Environmental Health Consultation Response

To	Hannah Kersley
Date	21-04-2026
Planning Ref	BR/59/26/DOC
Site Description	10 Longford Road Bognor Regis West Sussex PO21 1AQ
Date of Application	2026-04-13 00:00:00
Category	Discharge Of Condition
Recommendation	~~No Objection~~ ~~No Objection — with conditions~~ Objection ~~Holding Objection~~

BR/59/26/DOC

Proposed Site
1 : 50

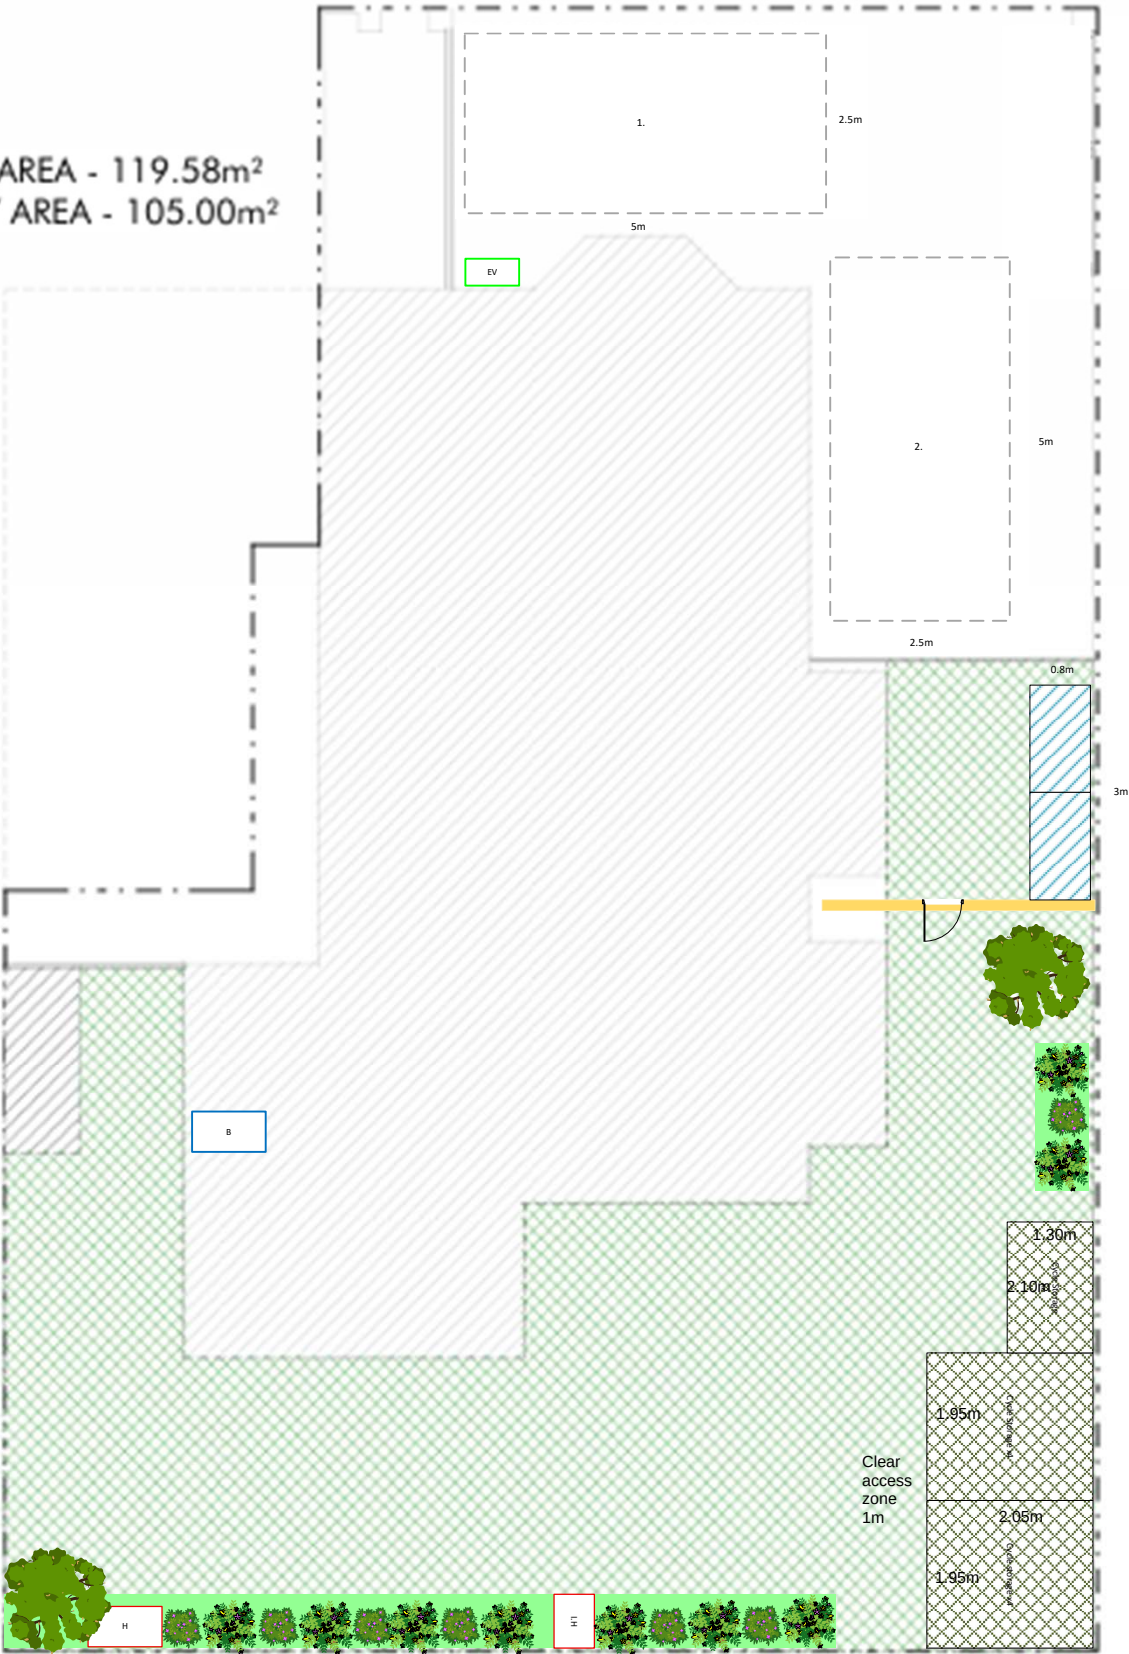
I have reviewed the submitted statement in relation to the discharge of condition 6 EV charging. The applicant has not submitted any evidence that the charger has been installed, and just states that one will be installed, and has not even decided on a make/model yet.

Stating a charger will be installed is not satisfactory to discharge the condition, we require evidence that it has been installed. Therefore, I must recommend refusal of this application to discharge condition 6 as it stands.
